ENG-CDR20004-R2-CD-GEC-redlines.pdf Markup Summary

Sheet
PROFILE STA 97+00 TO STA 10+00
PROFILE STA 10+00 TO STA 13+00
PROFILE STA 13+00 TO STA 16+00

GEC6

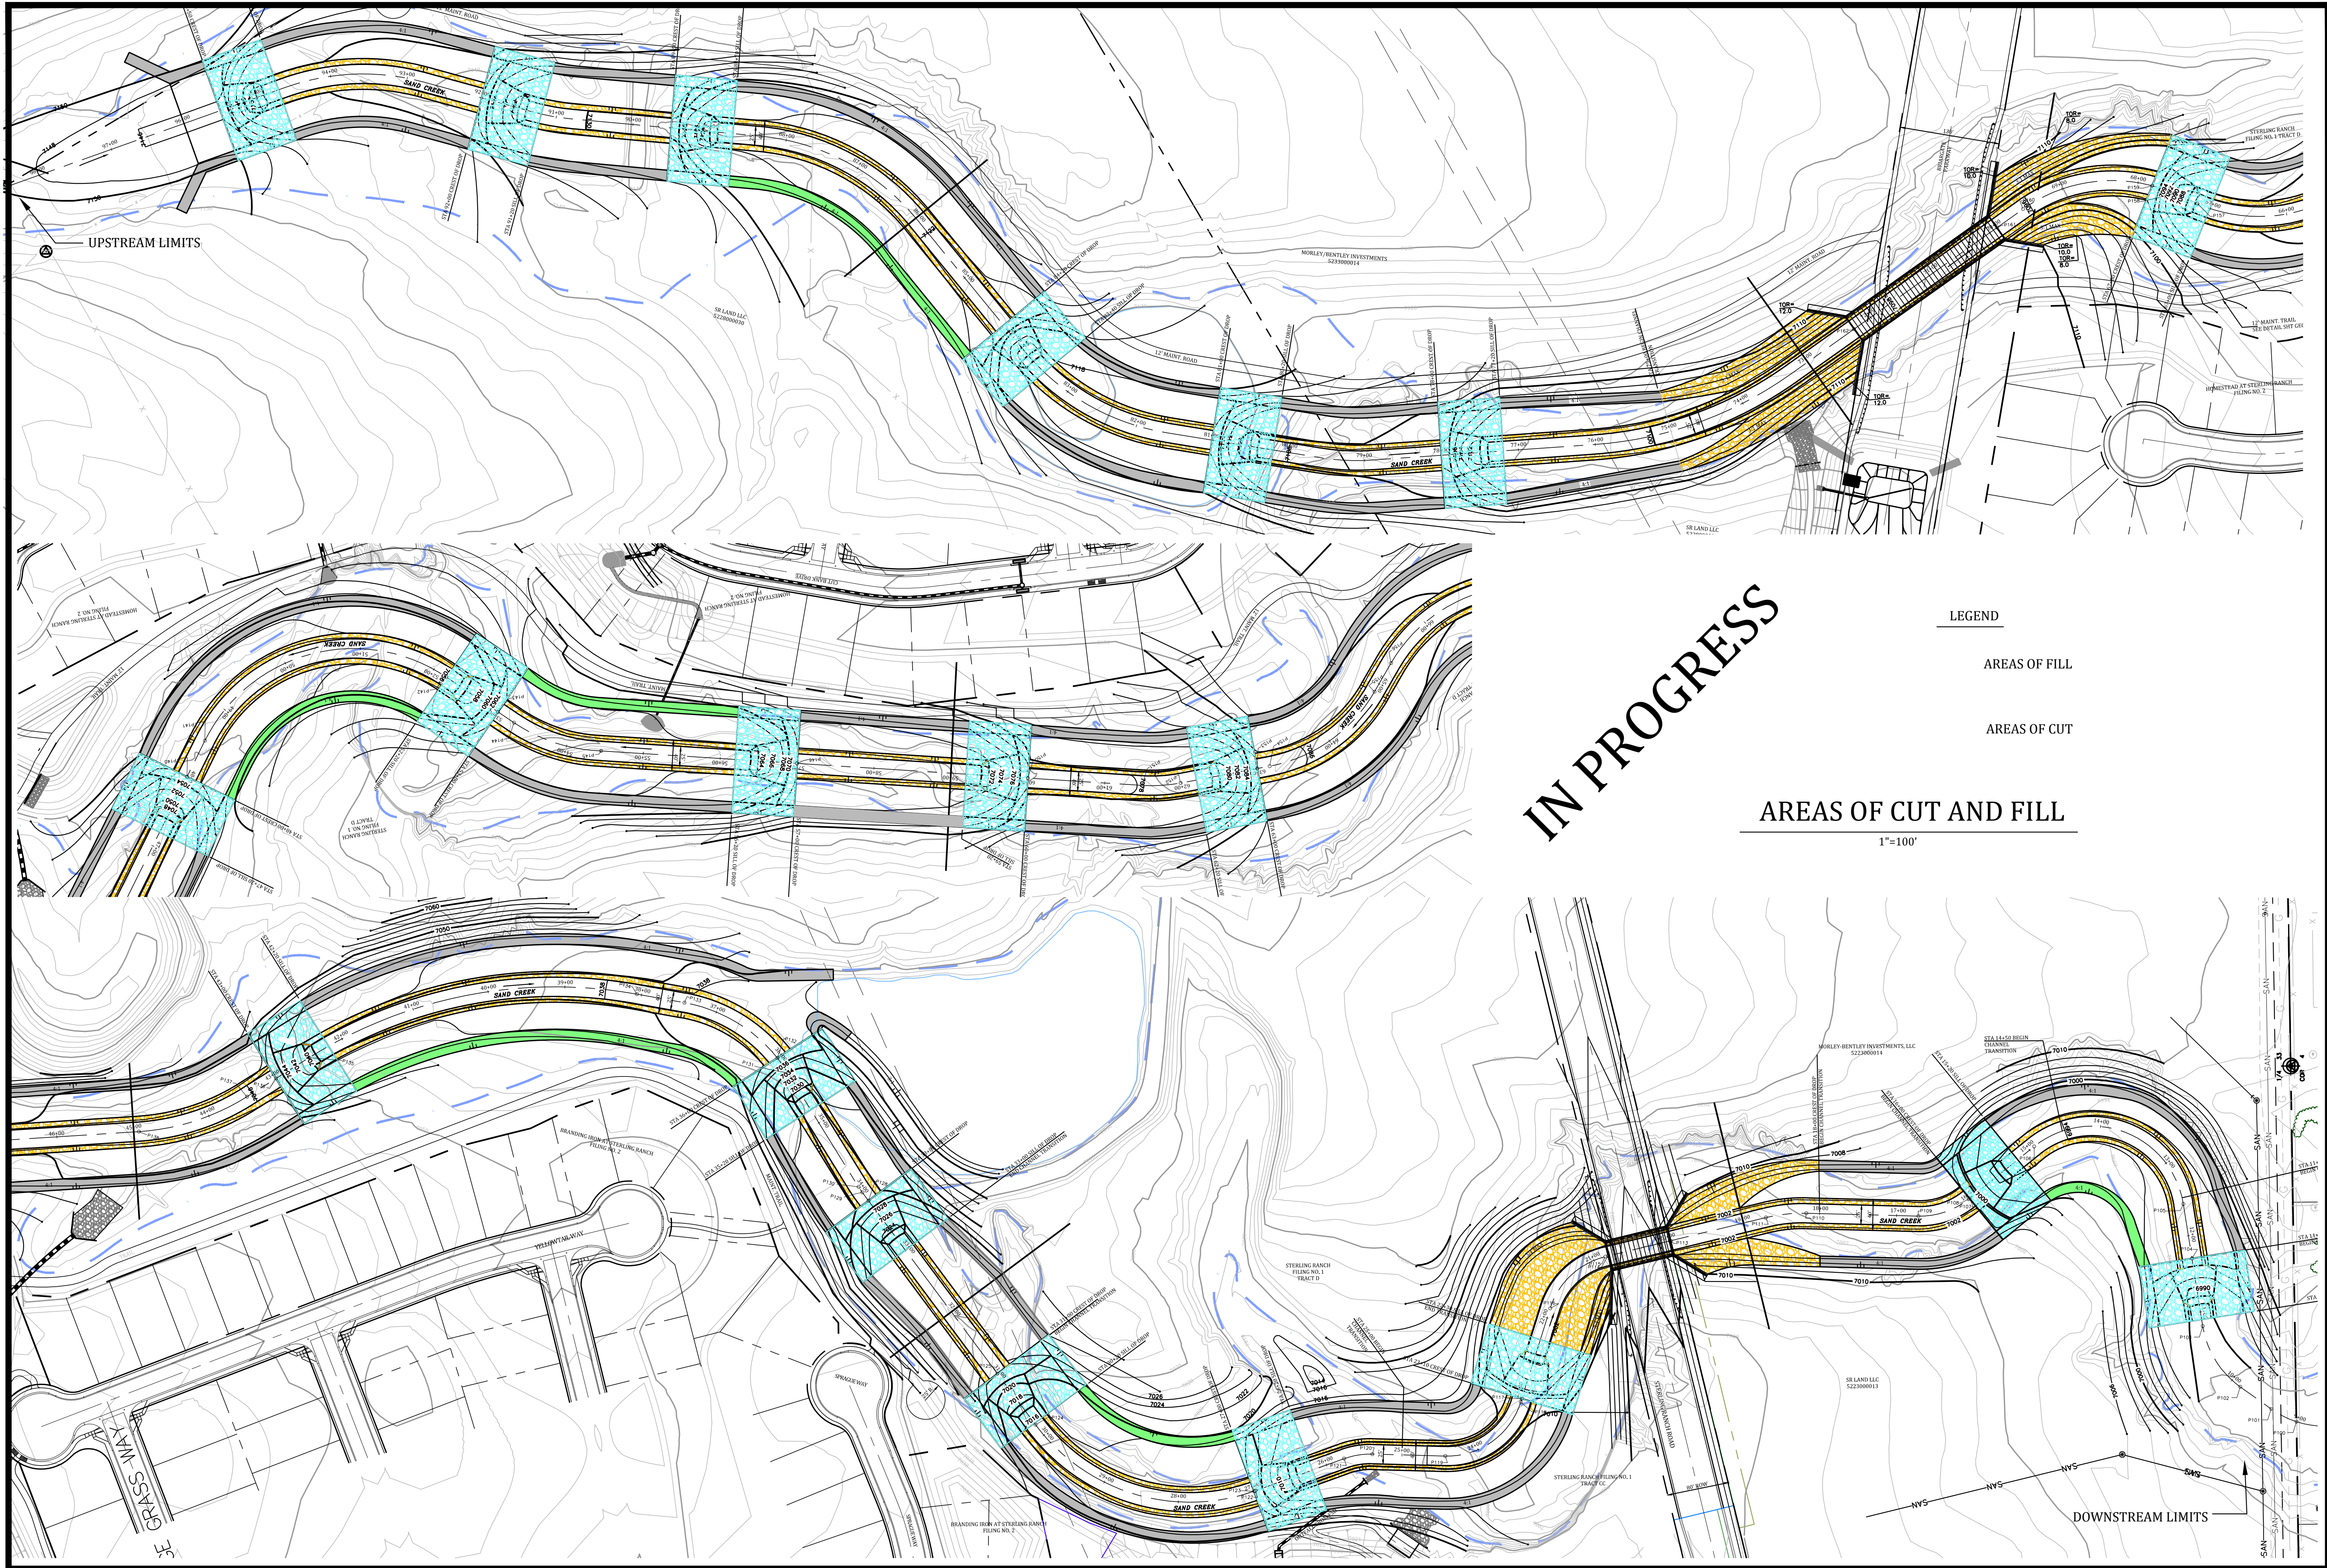
Show proposed areas of cut/fill Unresolved.
